**APPLICATION FOR DEREGISTRATION OF WALTON COMMON AND  
PROVISION OF LAND IN REPLACEMENT**

**Commons Act 2006: Section 16  
Consultation: S16: Commons Act 2006  
Location: Walton Common, West Tilbury, Essex**

Thurrock Flexible Generation Plant  
Access, Rights of Way and Traffic Regulation Plans  
Sheet 3 of 5

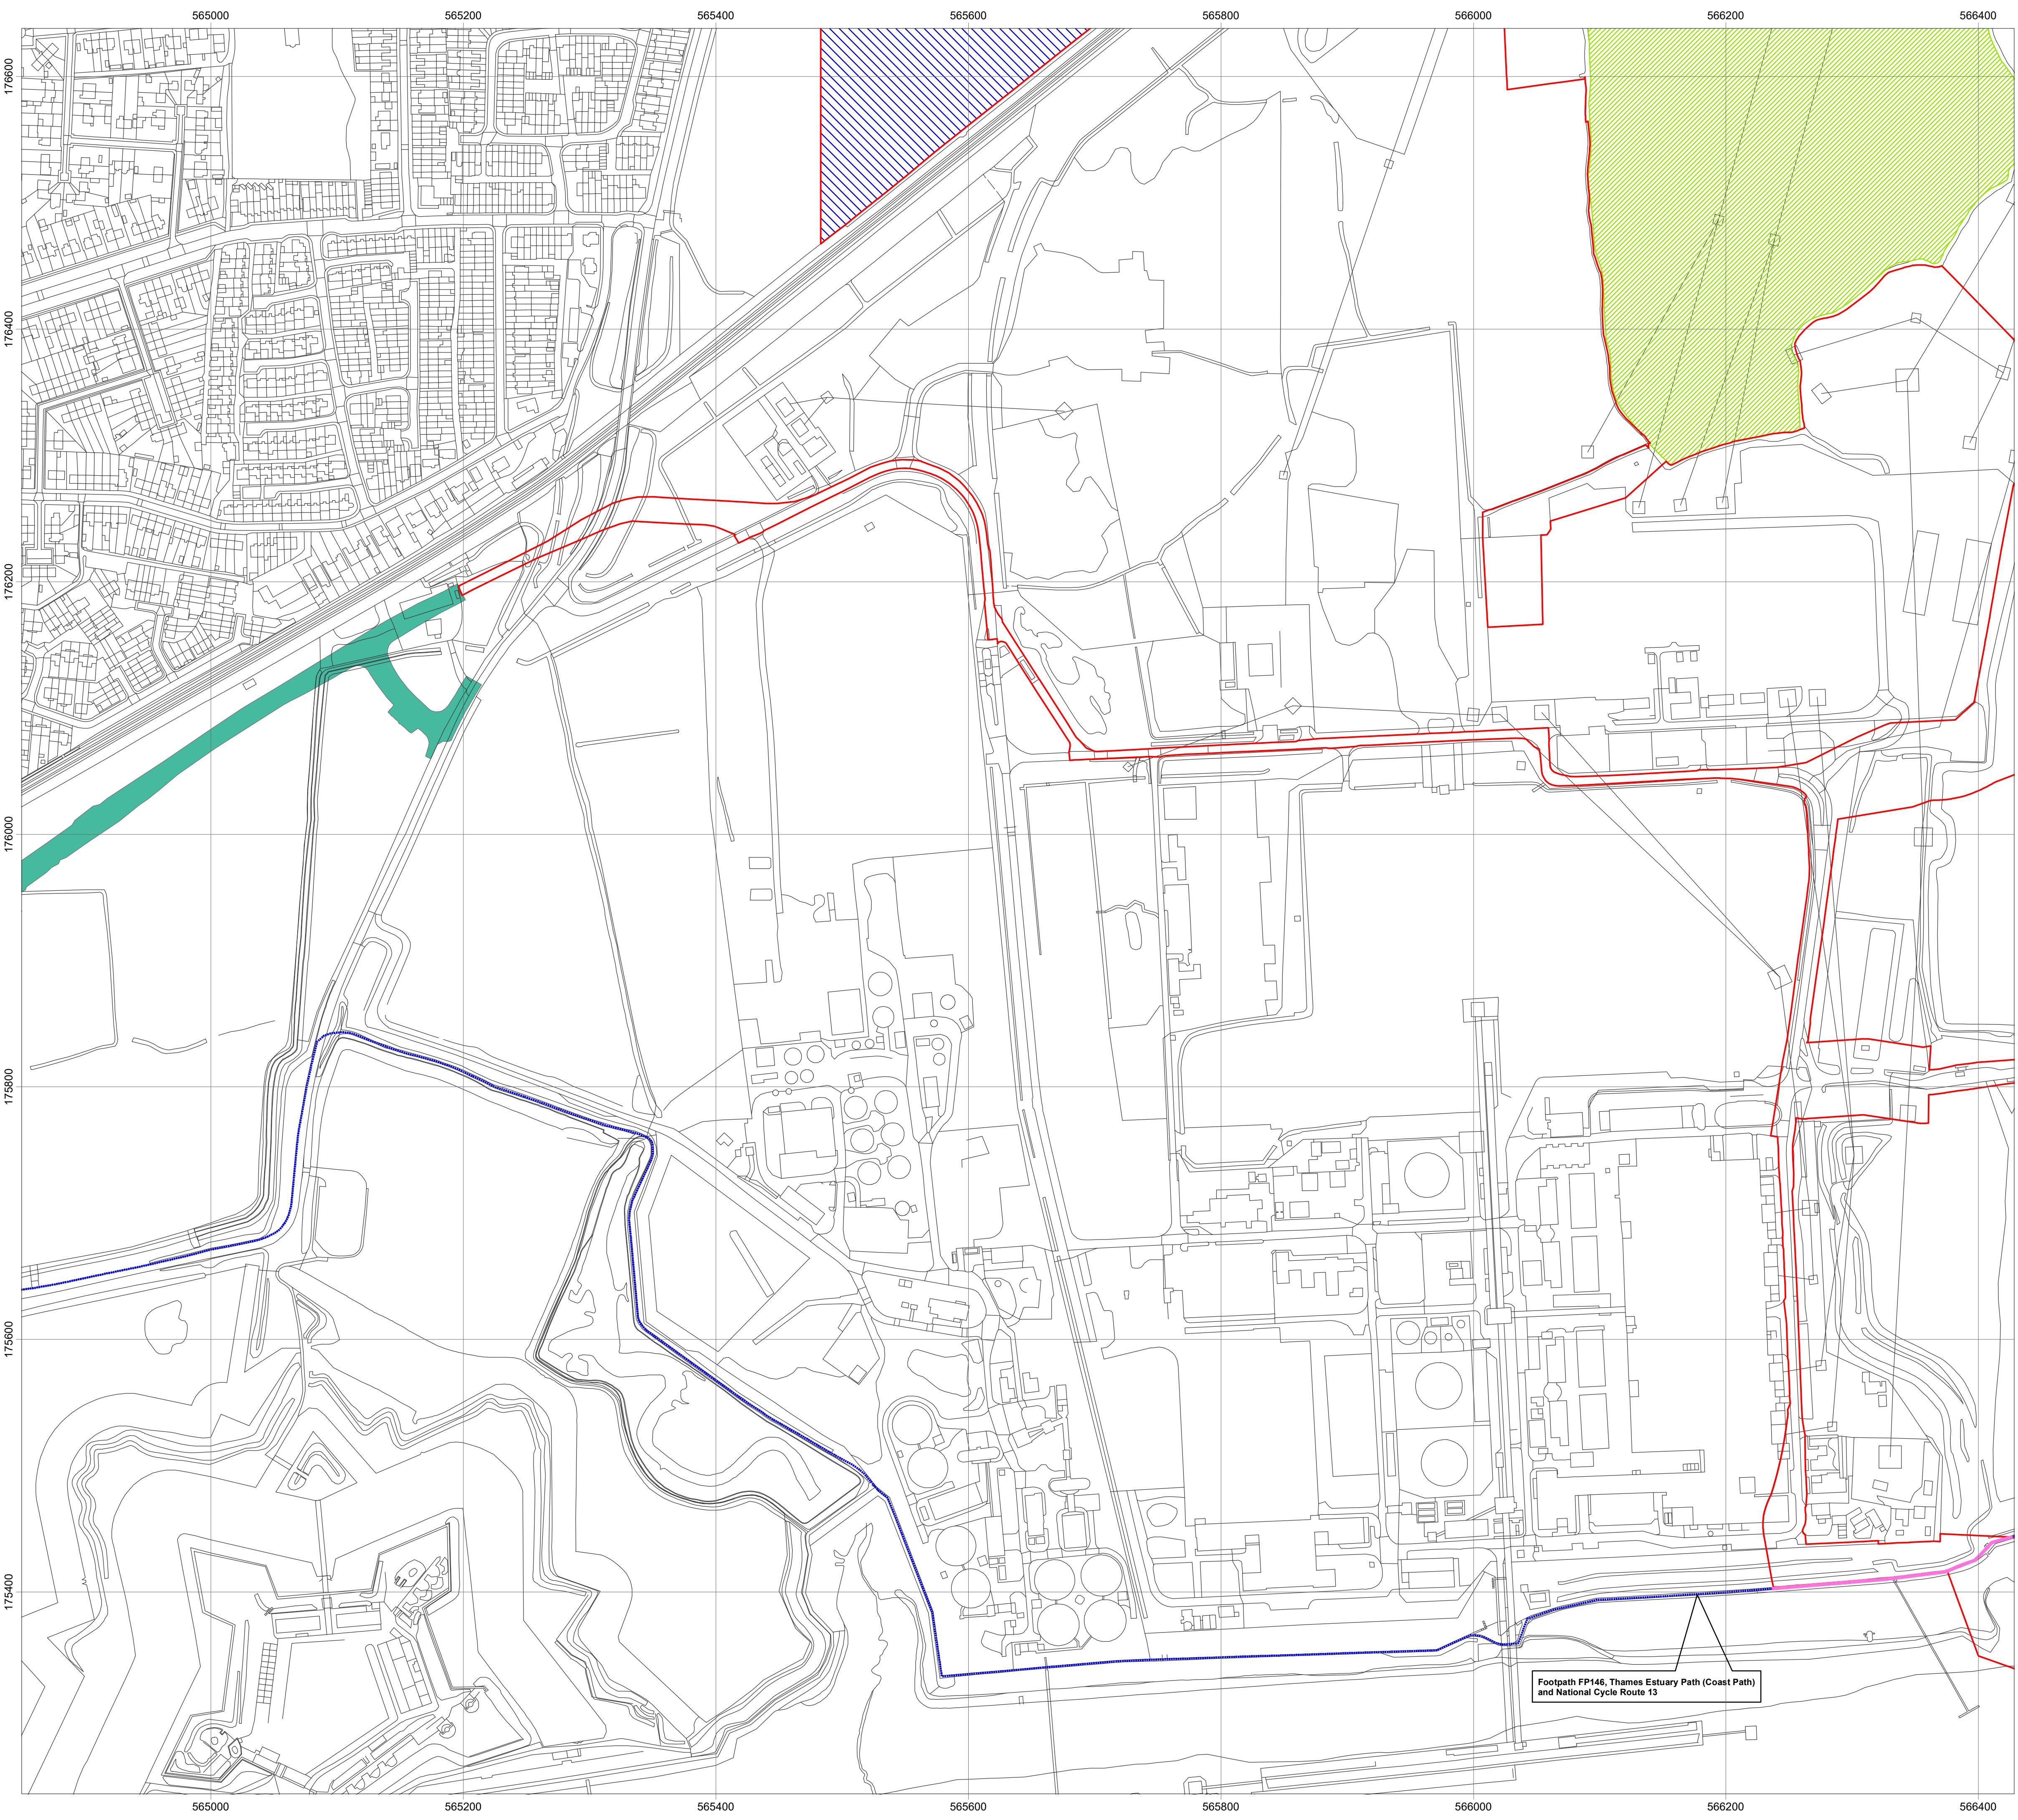
As set out in our pre application response the new common falls short of the Fort Hill Road by approximately 100 metres. This represents the closest point to the community of Tilbury. The applicant includes a proposal for a permissive route across the field to provide access from the Fort Hill Road onto the new area of

common. Following notification of the submission of the application we are aware that the intention remains to deal with this separately at some point in the future.

We have in our previous advice to the applicant asserted that this has the potential to be an exceedingly important route for members of the local community of Tilbury to access the common. The intention to provide a permissive route only is not in our view suitable as it will provide no certainty in law. Such routes with no basis in law can be revoked at any time by the landowner and should this route be revoked or removed at any time people from this community will need to walk some 1.7km in order to access the common from the opposite (eastern) boundary.

As part of pre application consultations we suggested that a further area of replacement land could have been offered or an agreement to create a Public Right of Way affording secure and convenient access for the local community. This would ensure that in line with the common land consents policy benefits to the neighbourhood could be fully realised. Our understanding is that there are currently no plans for either of the above suggestions to be taken forward.
